Comments for Planning Application F/YR22/0409/F

Application Number: F/YR22/0409/F

Address: 33B Doddington Road Benwick March Cambridgeshire PE15 0UT

Proposal: Erect side extension and porch to front, loft conversion to living accommodation with dormer to rear elevation and 1.8 metre high (max) wall/gate to front and sides of existing dwelling

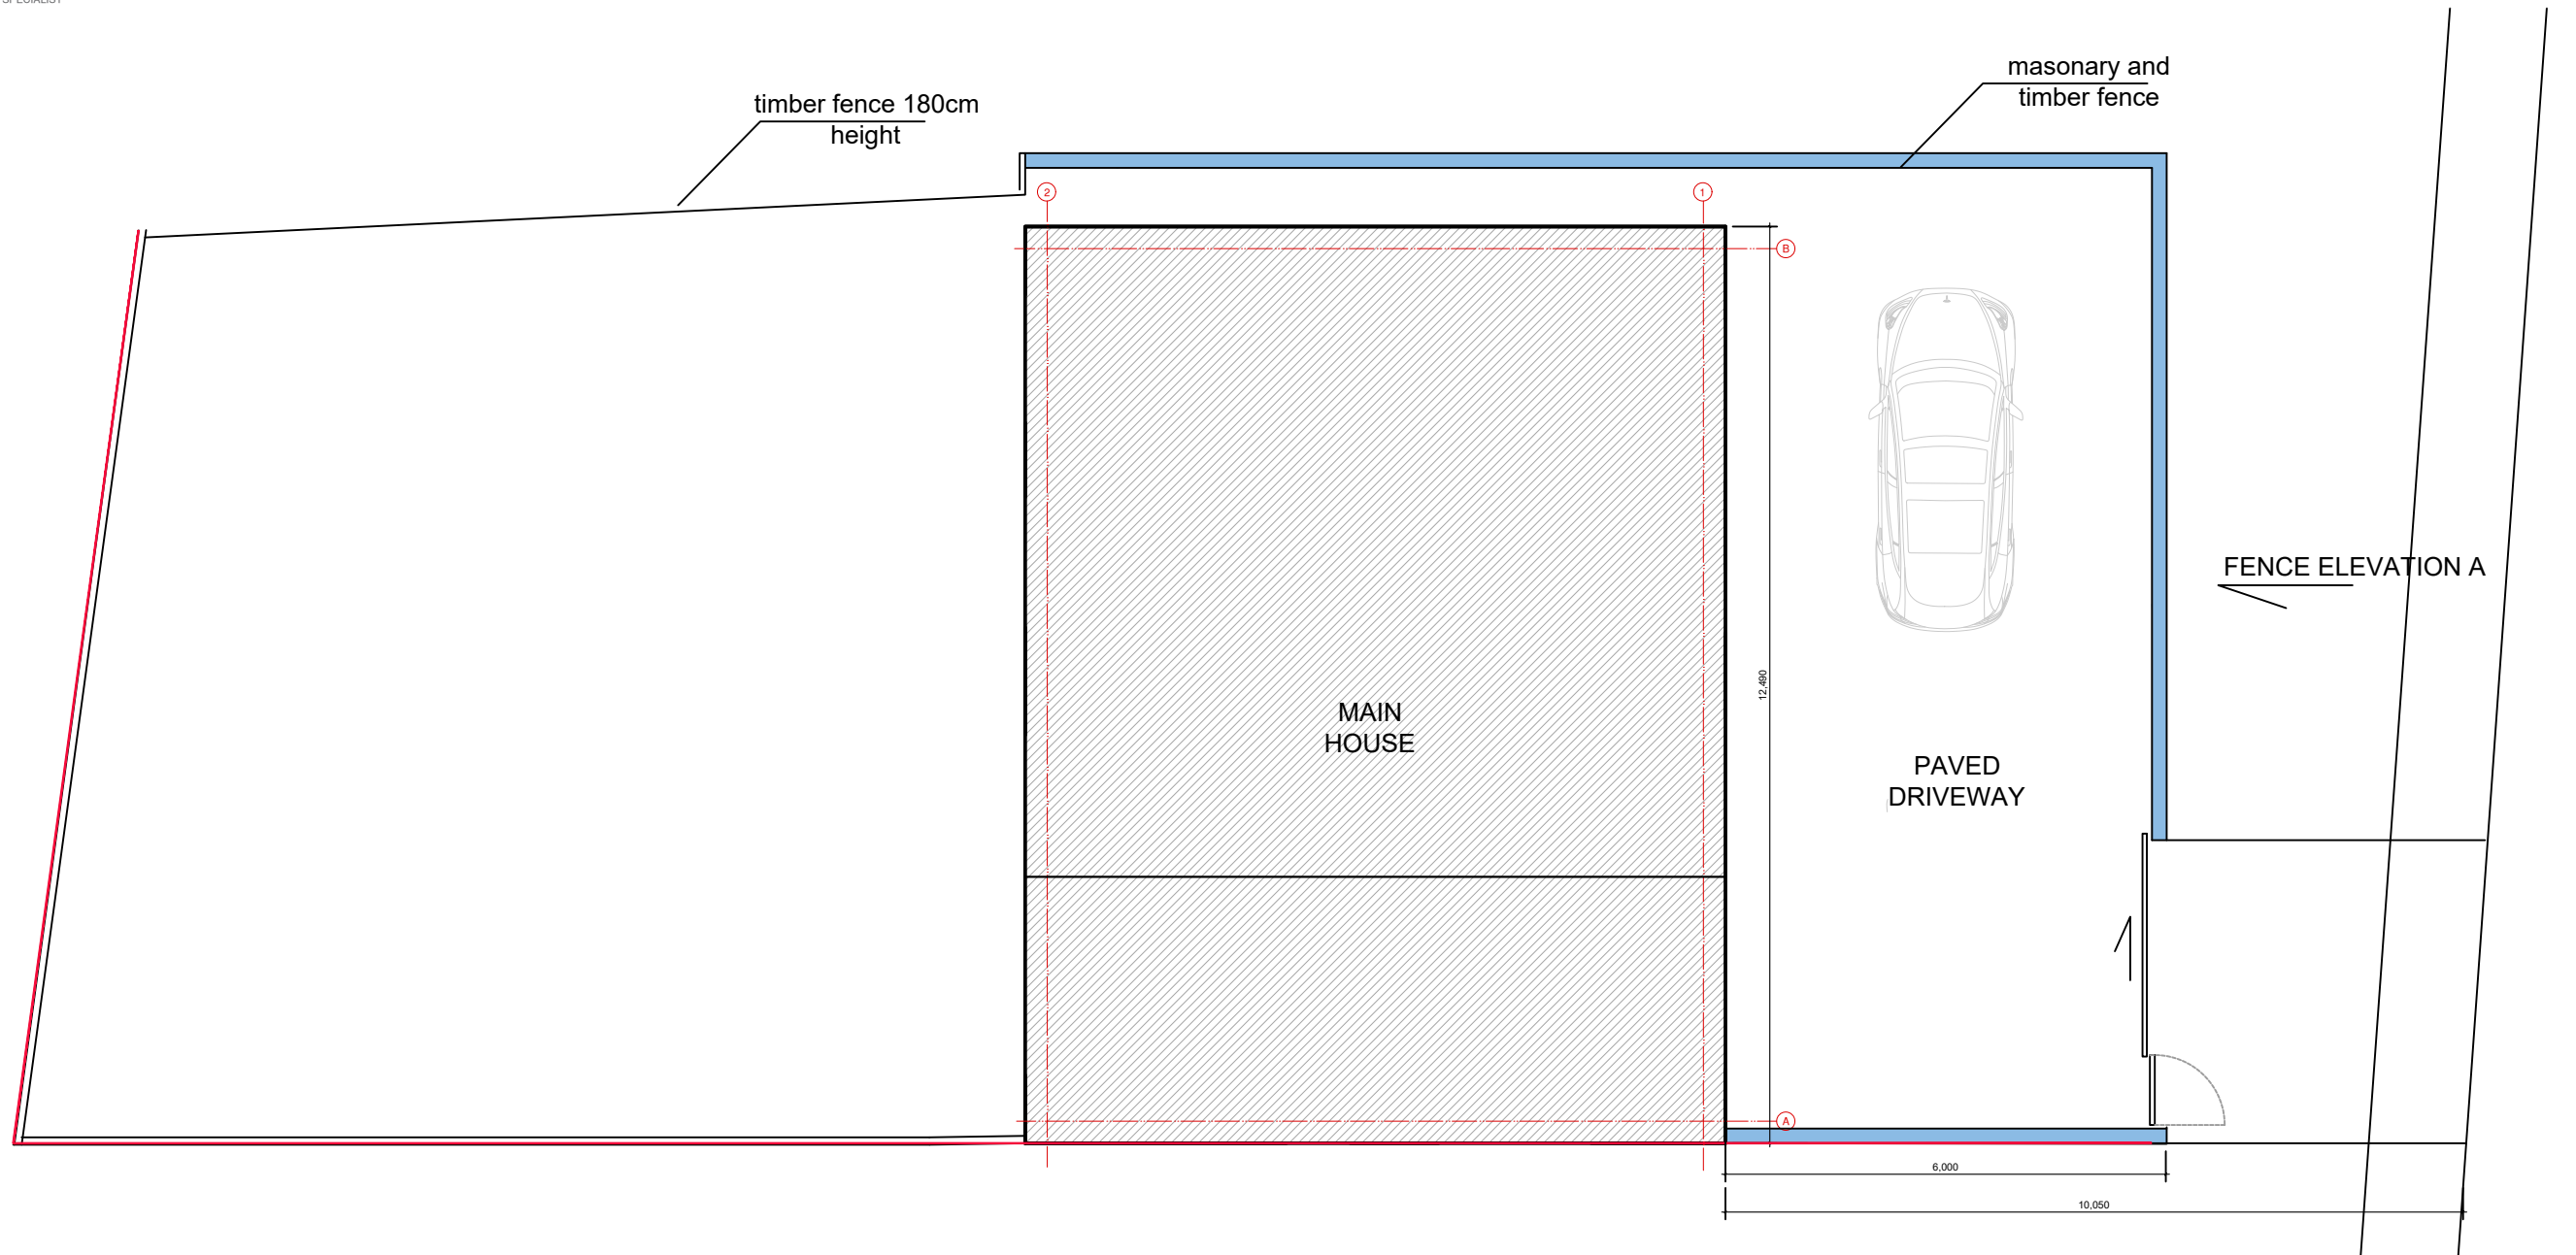
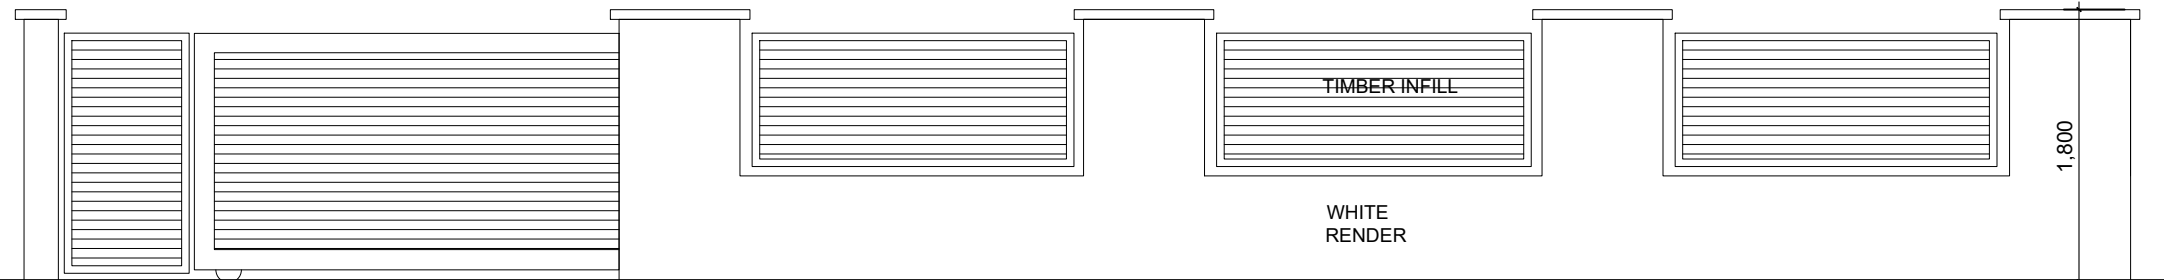
Comment: Our fence is the boundary between the 2 properties

And a metal shed that also forms part of the original boundaries mark as do the metal gates to the front of 33 there are

Supporting post for our own security and a garden water tap attached to the fence

We have no objections in a fence /wall being built as long it's within 33b side and the understanding all building will be done from that side and our property is left secure
